**PROPOSED RESIDENTIAL DEVELOPMENT, BERRY HILL ROAD, ADDERBURY (1899)
APPLICATION NUMBER 17/02394/OUT
RESPONSE TO HIGHWAY COMMENTS – FEBRUARY 2018**

This note will provide a formal response to transport and highways comments made by Oxfordshire County Council (OCC) in relation to the above planning application for residential development on land at Berry Hill Road in Adderbury. The comments were dated on 16th January 2018.

DRAWING NUMBER:	1899-F01	REVISION:	A
-----------------	-----------------	-----------	----------

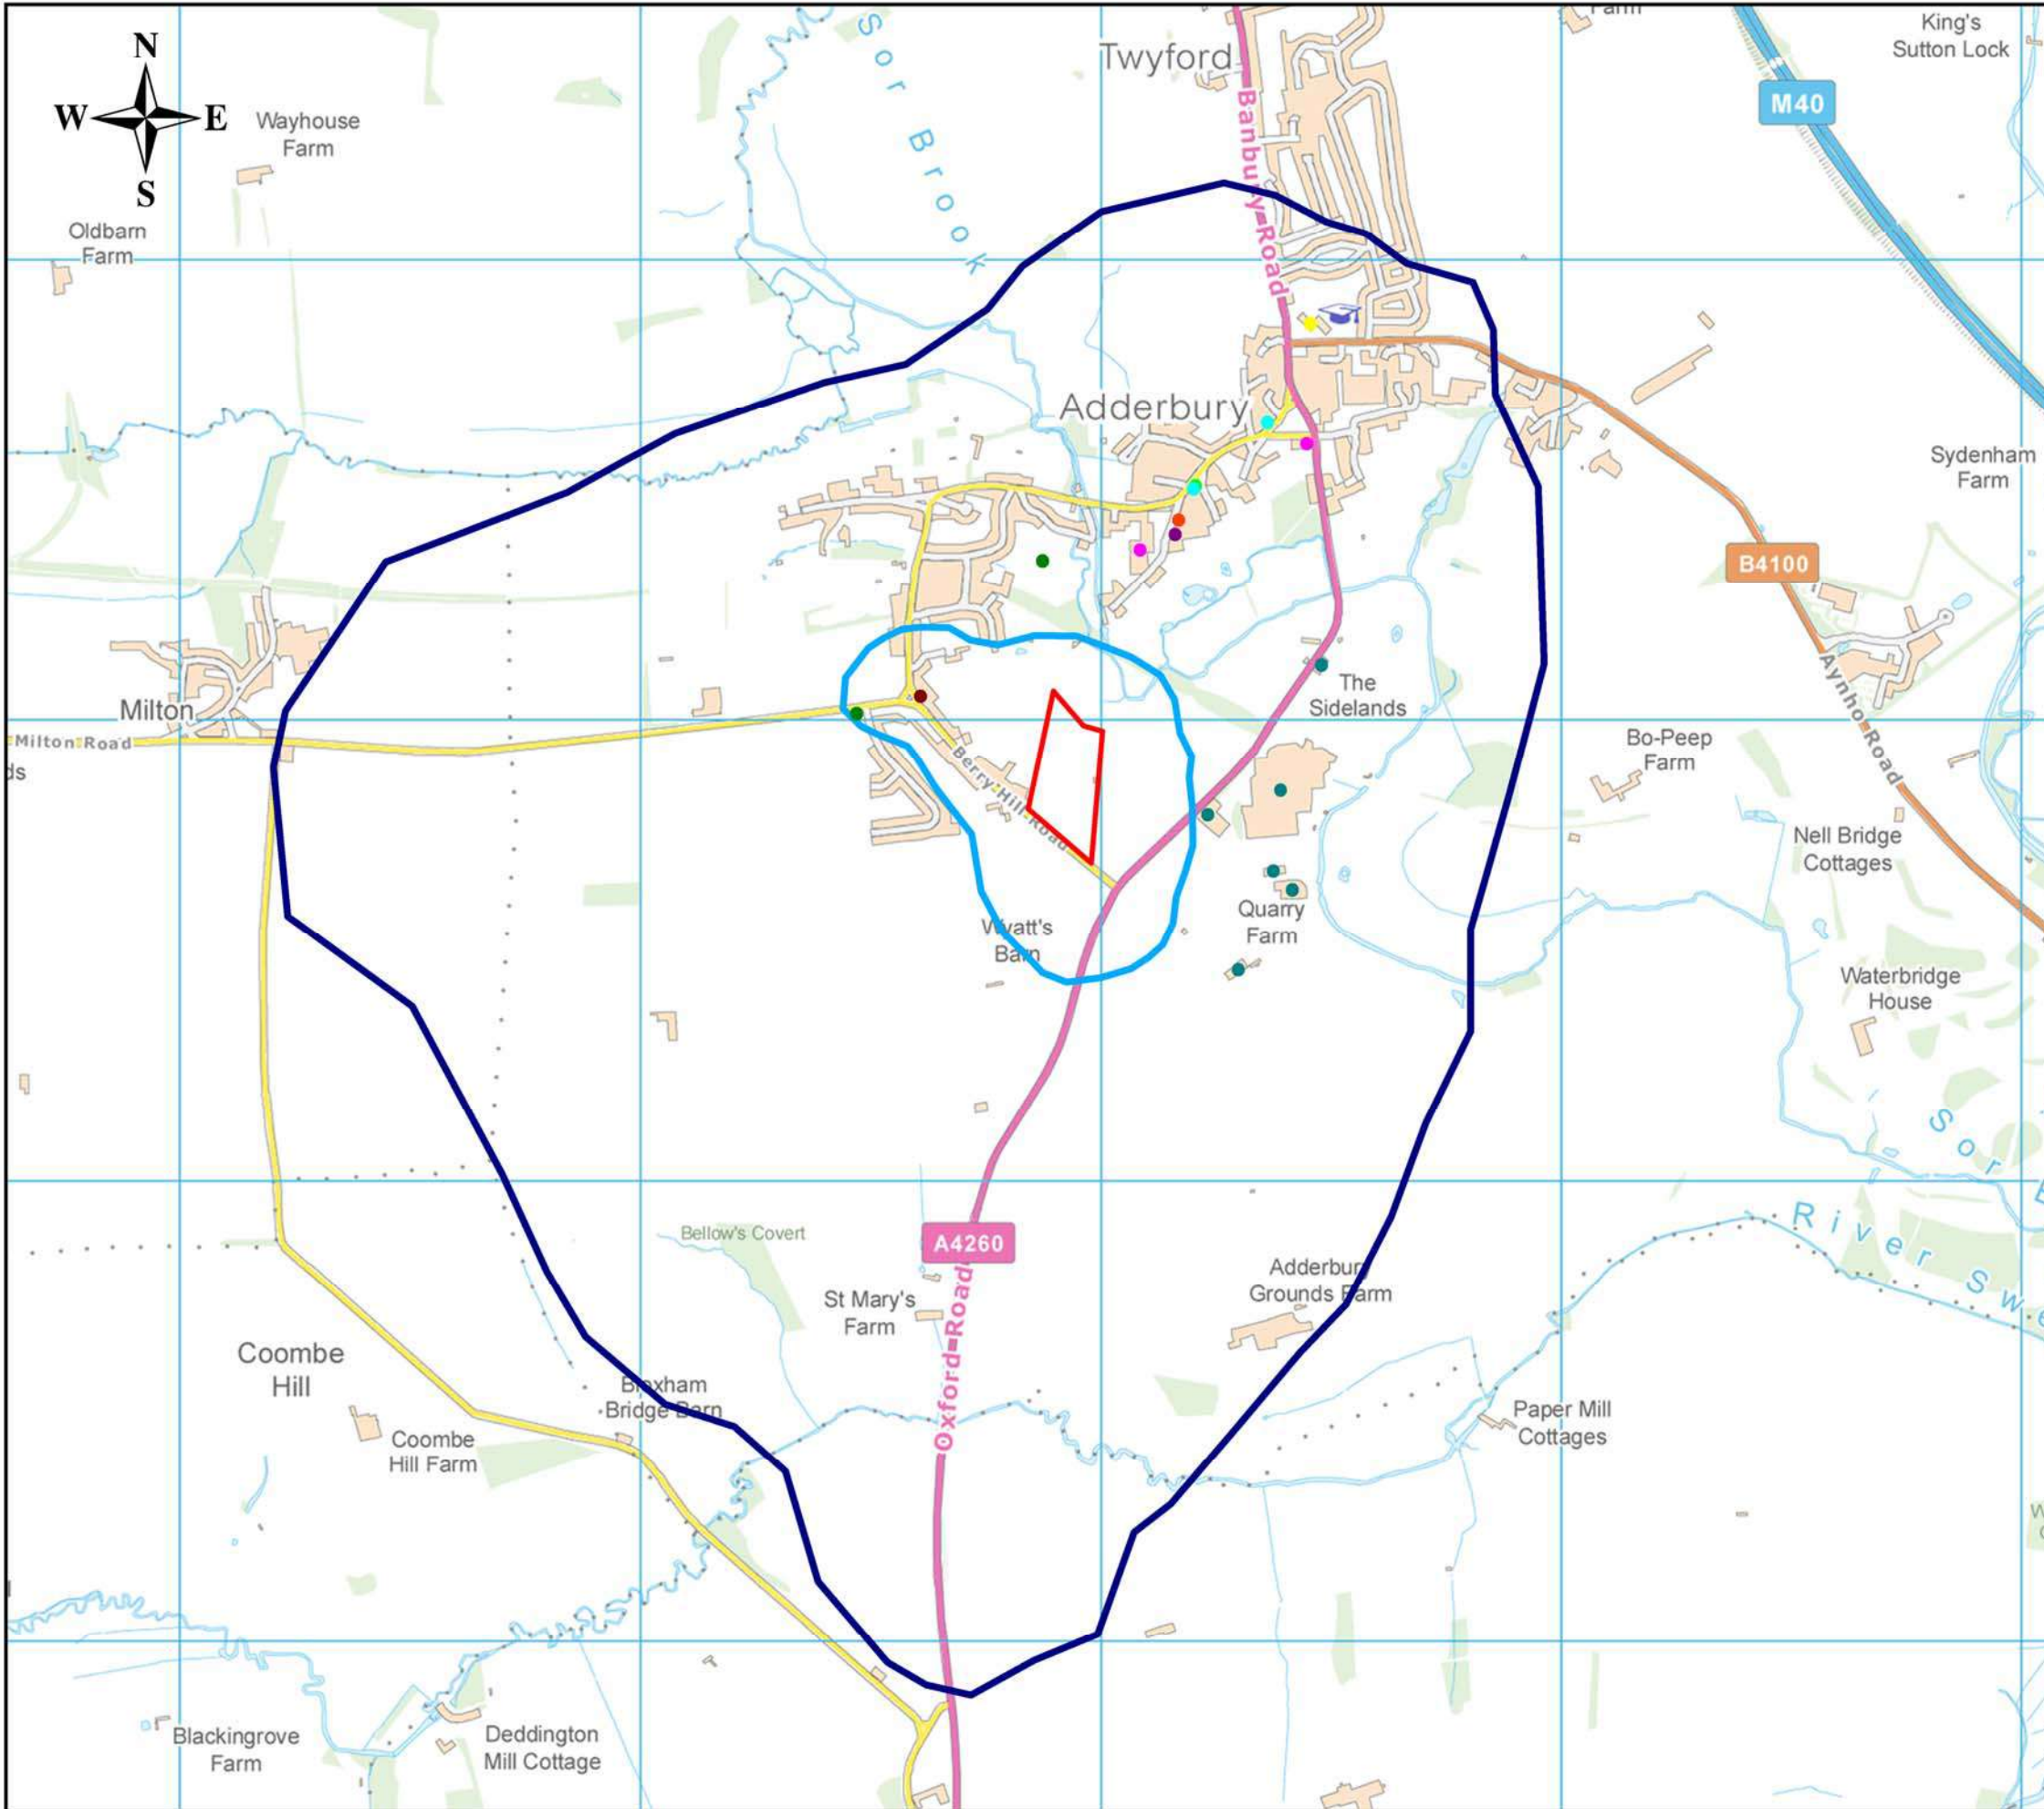
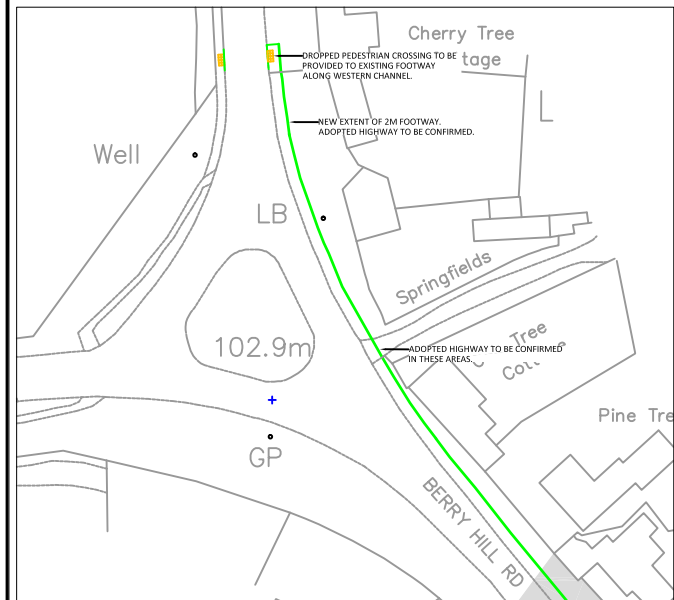
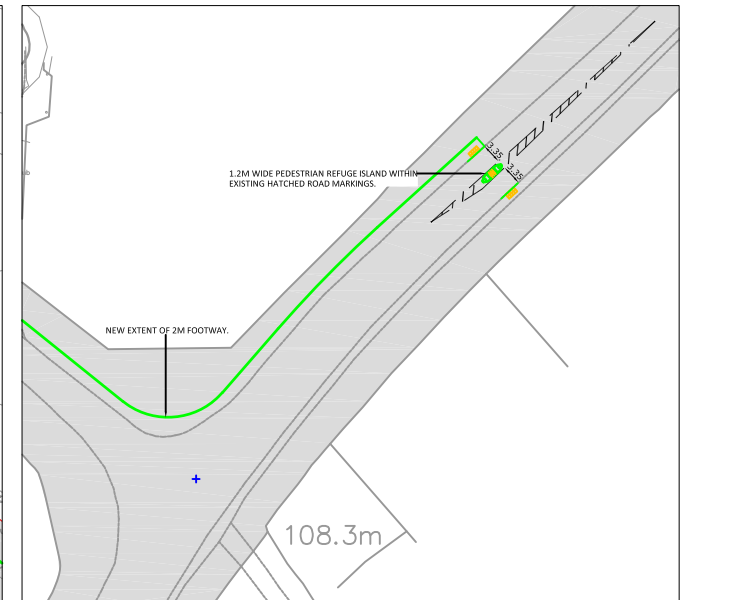
Drawing Number 1899-Fo1 Revision A shows a plan of the new footway which will be 2 metres in width and will be implemented via a Section 278 agreement which can be progressed if and when planning consent is granted at the site.

The grey shaded area on the plan shows the extent of adopted highway along the section of Berry Hill Road between Oxford Road and the junction with Horn Hill Road. The plan clearly shows that the new footway can be accommodated within the extent of adopted highway.

OCC have requested that clarification is added to the plan in terms of additional annotation. This has been done on the above mentioned plan and this can be conditioned as part of any consent at the site to ensure its delivery.

These speeds would require visibility splays at the site access junction of 120 metres which are also based on the guidance within the Design Manual for Roads and Bridges (DMRB), as requested by OCC, rather than the more appropriate, in our view, Manual for Streets. These are shown on the Site Access plan on **Drawing Number 1899-Fo1 Revision A** and are shown to be achievable on land within the site or on adopted highway.
